Environmental Assessment Exhibition: Part 3A Major Project (07_0010) Concept Plan and Project Application Proposal for Residential, Commercial and Tourist Development and Environmental Works at Ocean Drive Lake Cathie, Port Macquarie-Hastings Local Government Area.

OCEAN DRIVE, LAKE CATHIE, CONCEPT PLAN AND PROJECT APPLICATION (MP 07 0010)

DECCW COMMENTS ON ENVIRONMENTAL ASSESSMENT

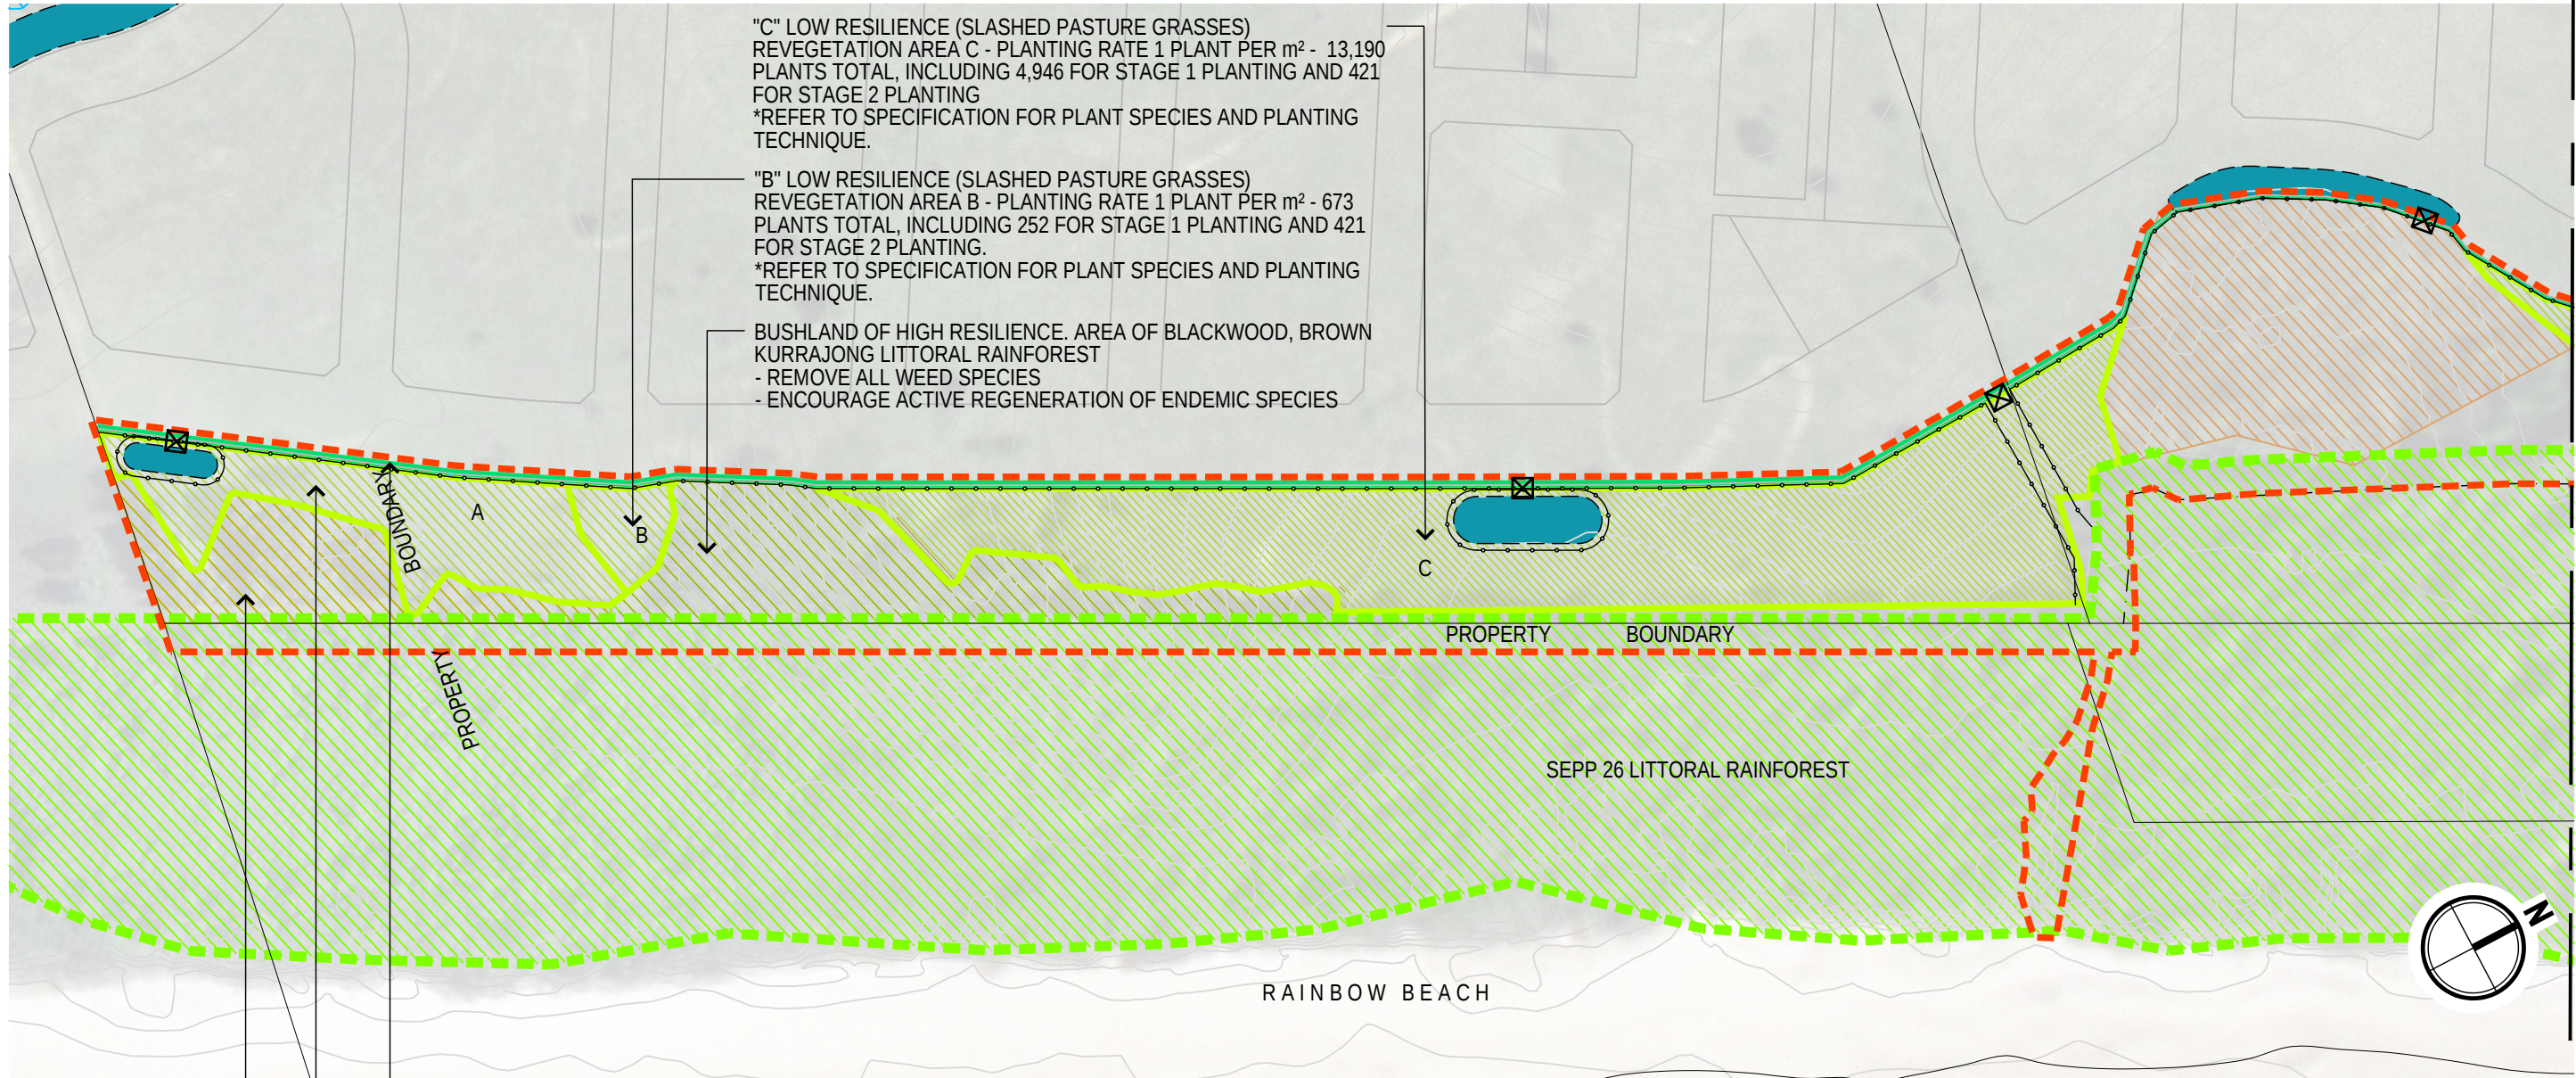
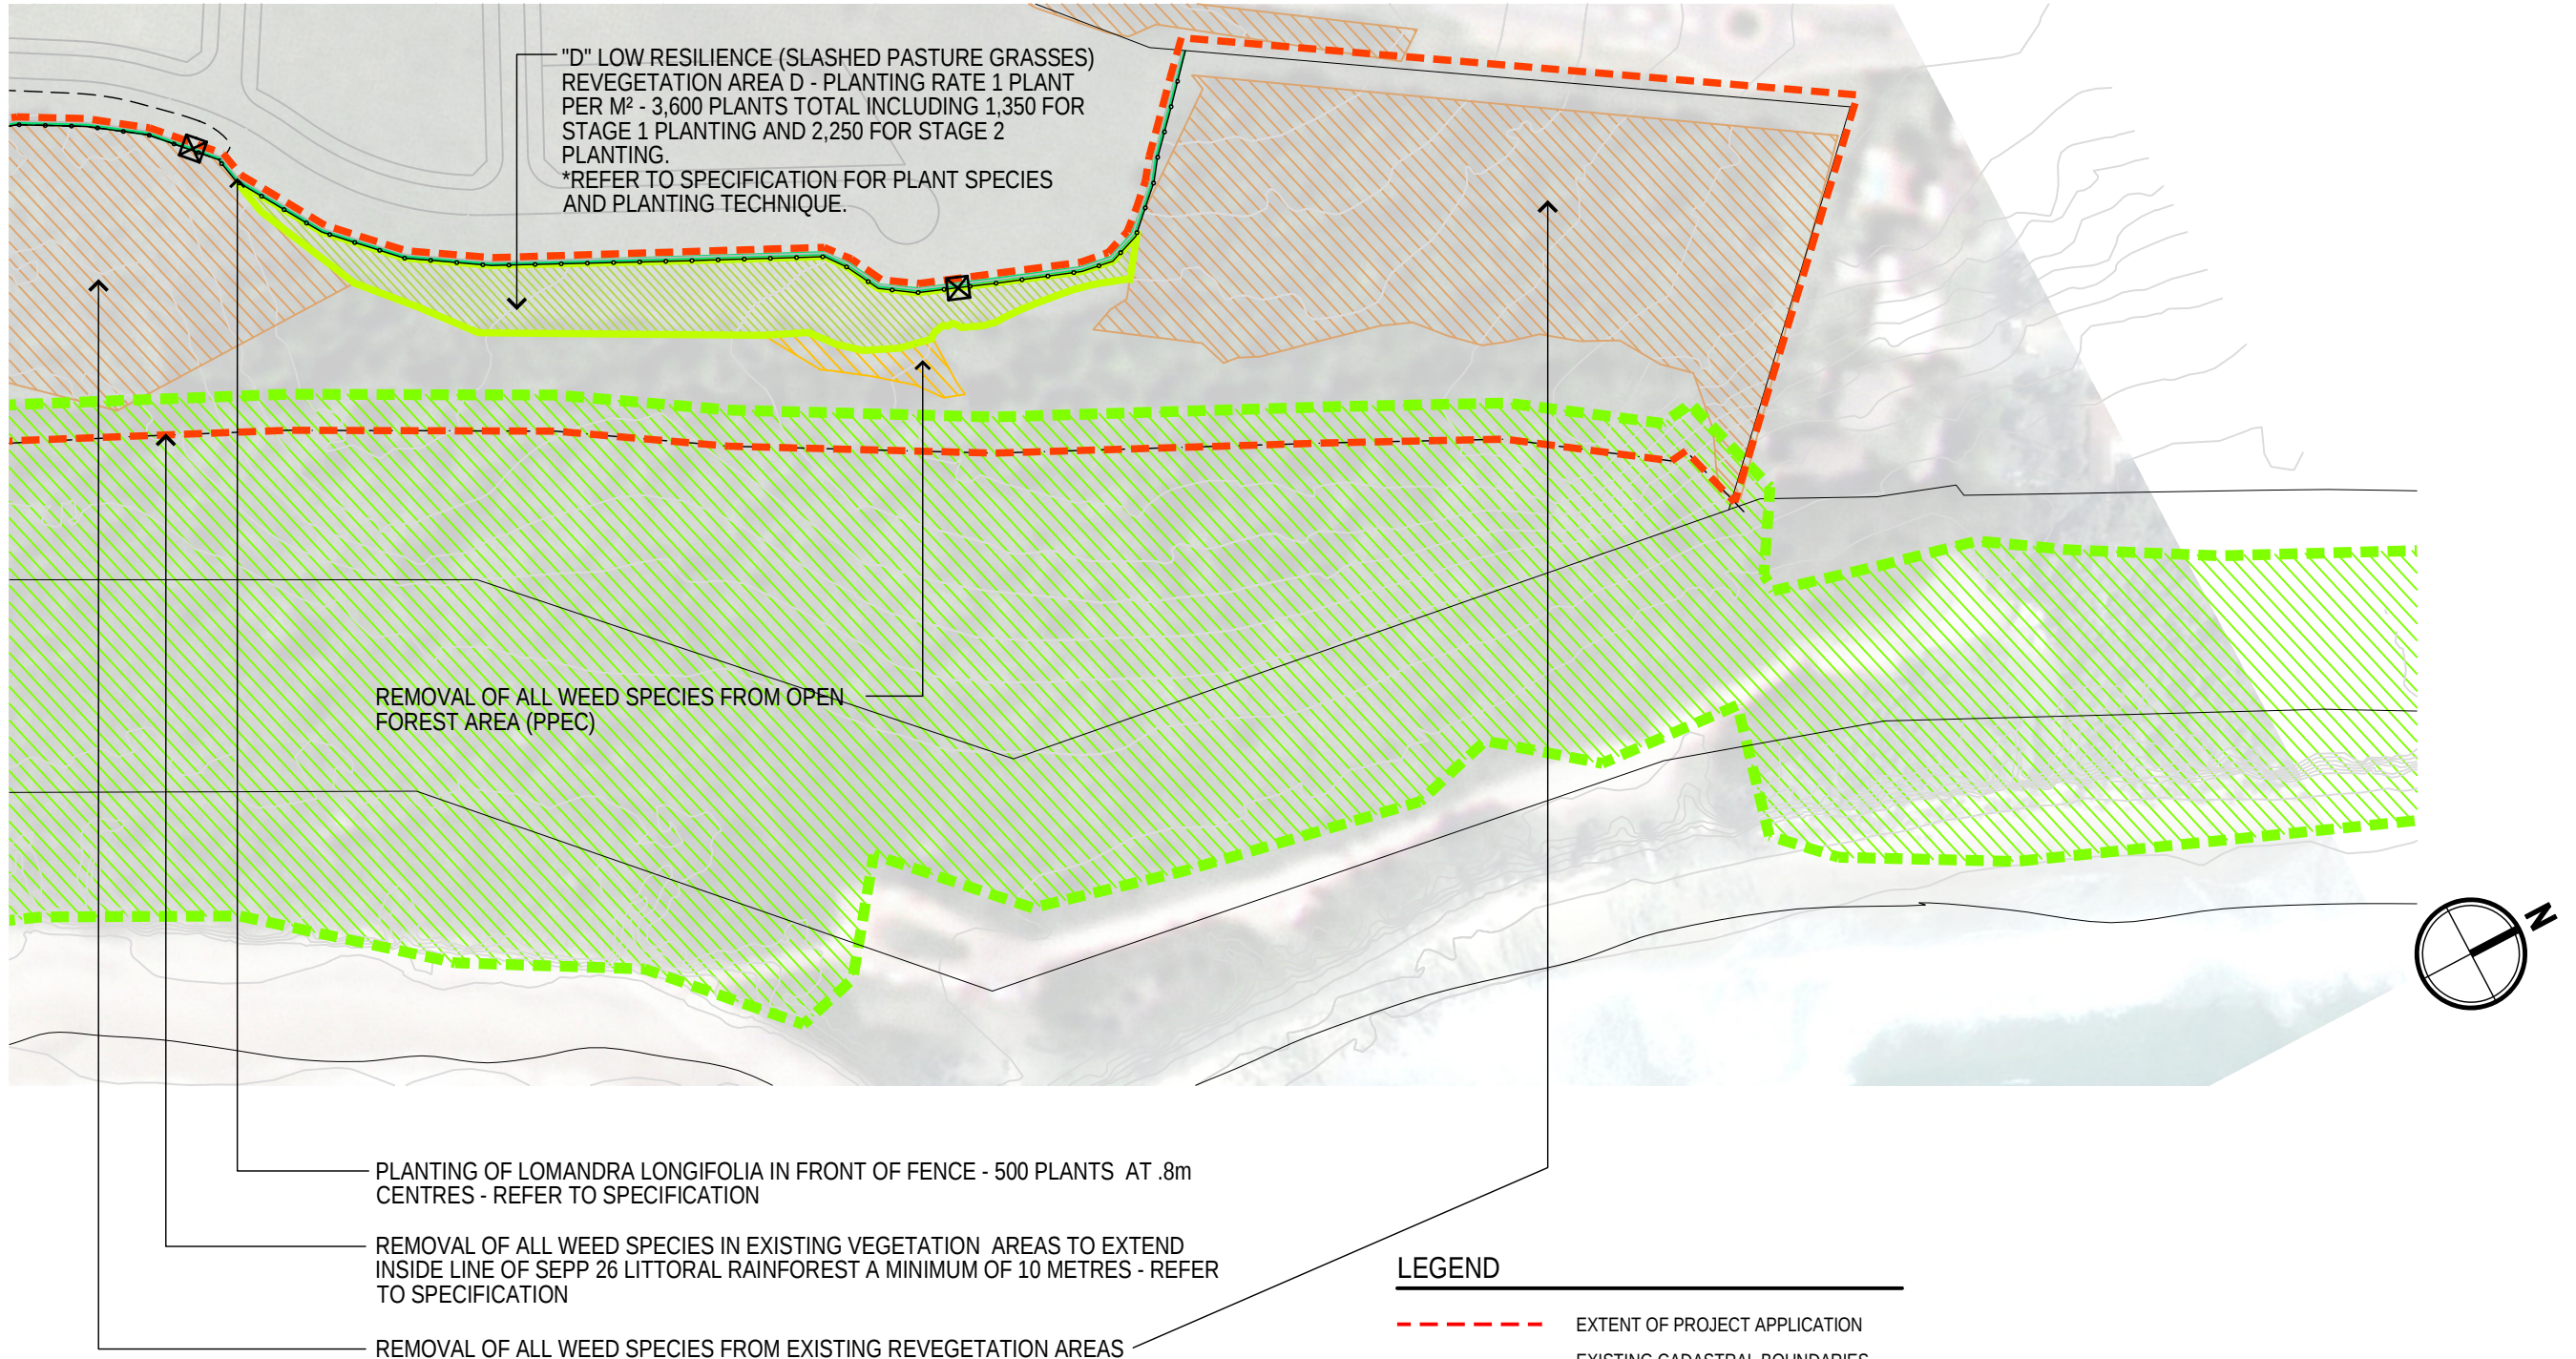
9. A 100 metre buffer must be retained between any proposed development on the subject site (i.e. development footprint) and any areas of mapped littoral rainforests under 'State Environmental Planning Policy (SEPP) No 26—Littoral Rainforests'. SEPP 26 littoral rainforest is mapped on the subject site (i.e. Lot 1 DP 374315 and Lot 4 DP 615261) and the adjacent Crown Reserve (i.e. R 754444 and R 82555 as schematically shown 'Exhibit03_AerialPhotograph.pdf' document), which are located to the east of the proposal.

The exhibited EA recommends a 40-60 m buffer, however, DECCW believe these to be inadequate and not in accordance with SEPP 26 – Littoral Rainforests, which recommends a 100 m from the outer edge of land mapped as littoral rainforests. DECCW recommends that this minimum buffer of 100 metres be retained to protect 'environmentally sensitive areas' and vegetation which is considered to represent 'Littoral Rainforest in the NSW North Coast, Sydney Basin and South East Corner Bioregions' endangered ecological community (EEC) under Schedule 1 of the *NSW Threatened Species Conservation Act 1995*; as well as remaining consistent with the objectives of the SEPP.

Typical Boardwalk Section

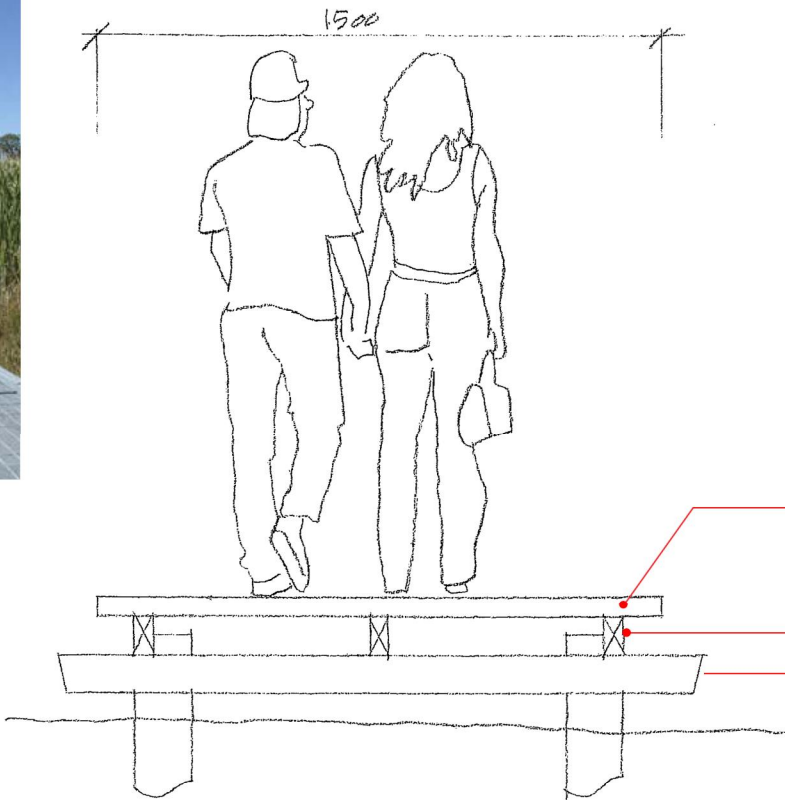
10. Development, erection and all works associated with the construction of the proposed pedestrian boardwalk through the mapped 'SEPP 26 – Littoral Rainforest' and 'Littoral Rainforest' EEC must only occur within the existing track footprint (i.e. 2.2 m wide track), as schematically shown 'ExhibitPA06_RainforestBoardwalkSheet1.pdf' document.

To protect the 'SEPP 26 – Littoral Rainforest' and 'Littoral Rainforest' EEC, and prevent further edge clearing / damage of this environmentally sensitive community.
